Application No: M/94/24/PL

Site Address: Sea Willow 35 Central Drive Middleton-on-sea PO22 7TT

Description of works: Change of use from beach to garden and erection of a 3' single post and rope fence. This application is in CIL Zone 4 (Zero Rated) as other development.

Thank you for your internet representation made on 16th January 2025 which has been recorded as an objection with the comments as follows:

Site plan 1:500

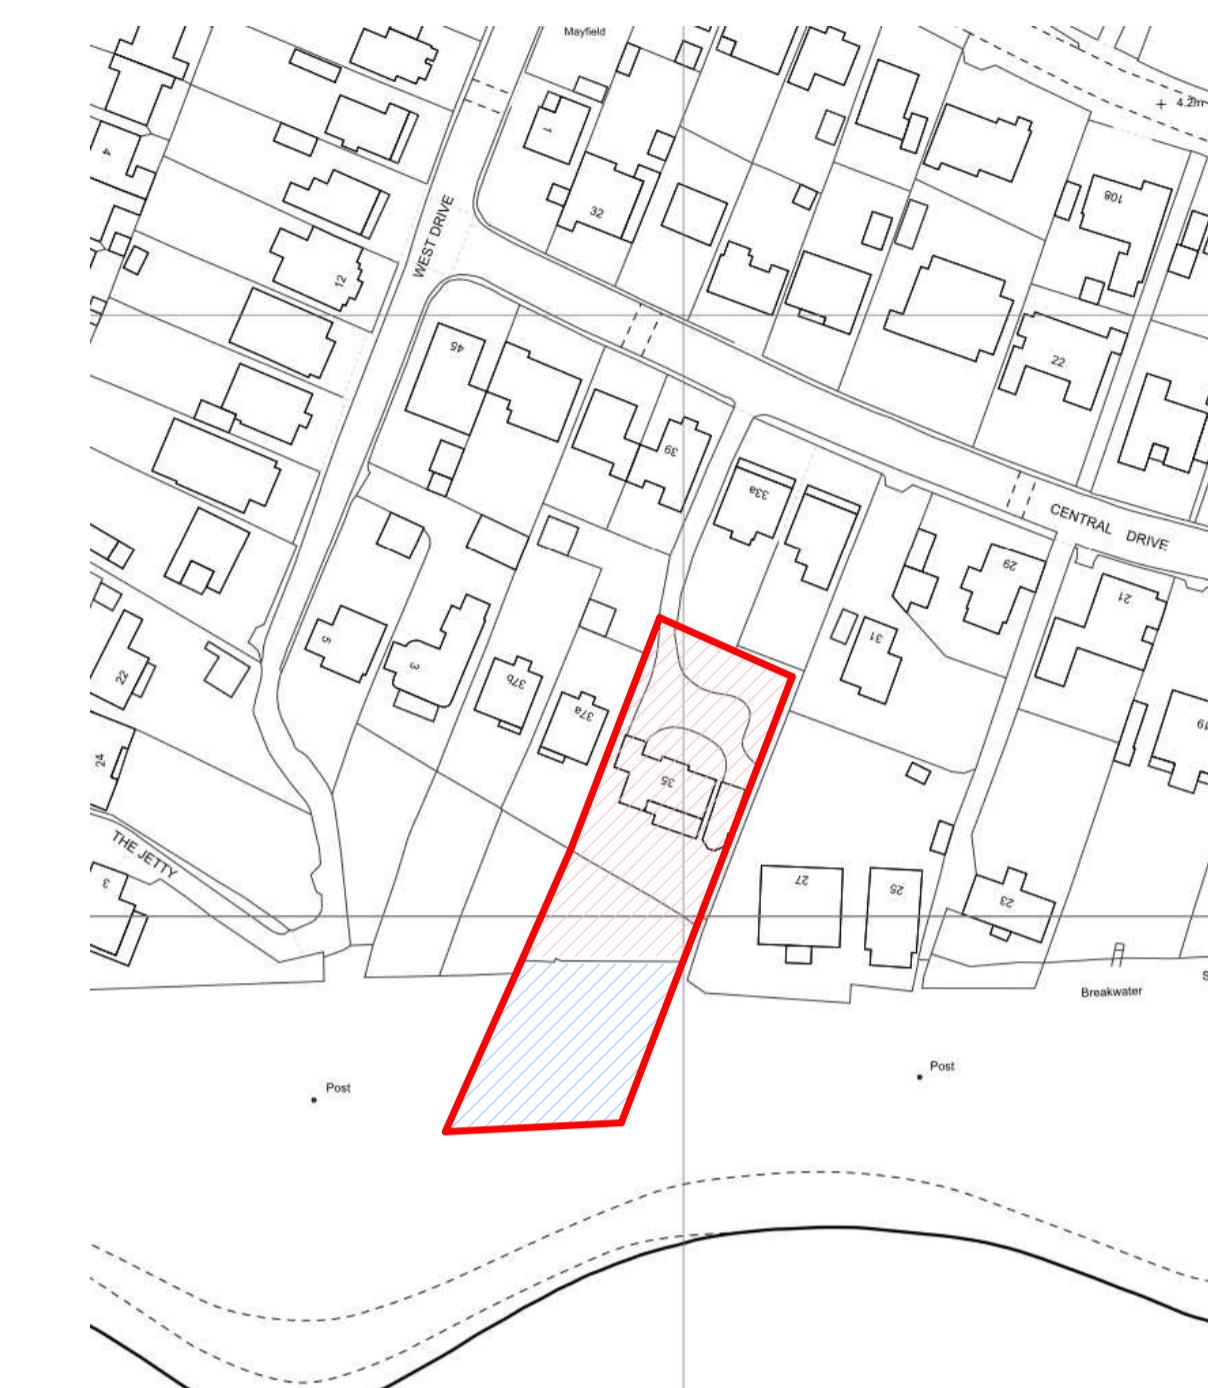
This application should be rejected for being in breach of the provisions of the National Trail established in 2009 (renamed the King Charles III Coastal Path in 2023). In short, the legal right of public access should be secured. Please see extract of The Highways Act 1980 below:

This refers to the erection of a building, fence or hedge in a highway.

In addition, the area in question appears to fall within Arun District Council's rock island sea defences where shingle areas were installed as part of the sea defence programme. With the erosion of the shingle area, the mean high water mark is forever moving so the land registry record dated 1993 does not accurately represent the mean high water mark or boundary of today. This point is highlighted in the Land Registry Location Plan stating "the title plan shows the general position, not exact lines, of the boundaries". It is therefore misleading to rely on this when making planning decisions.
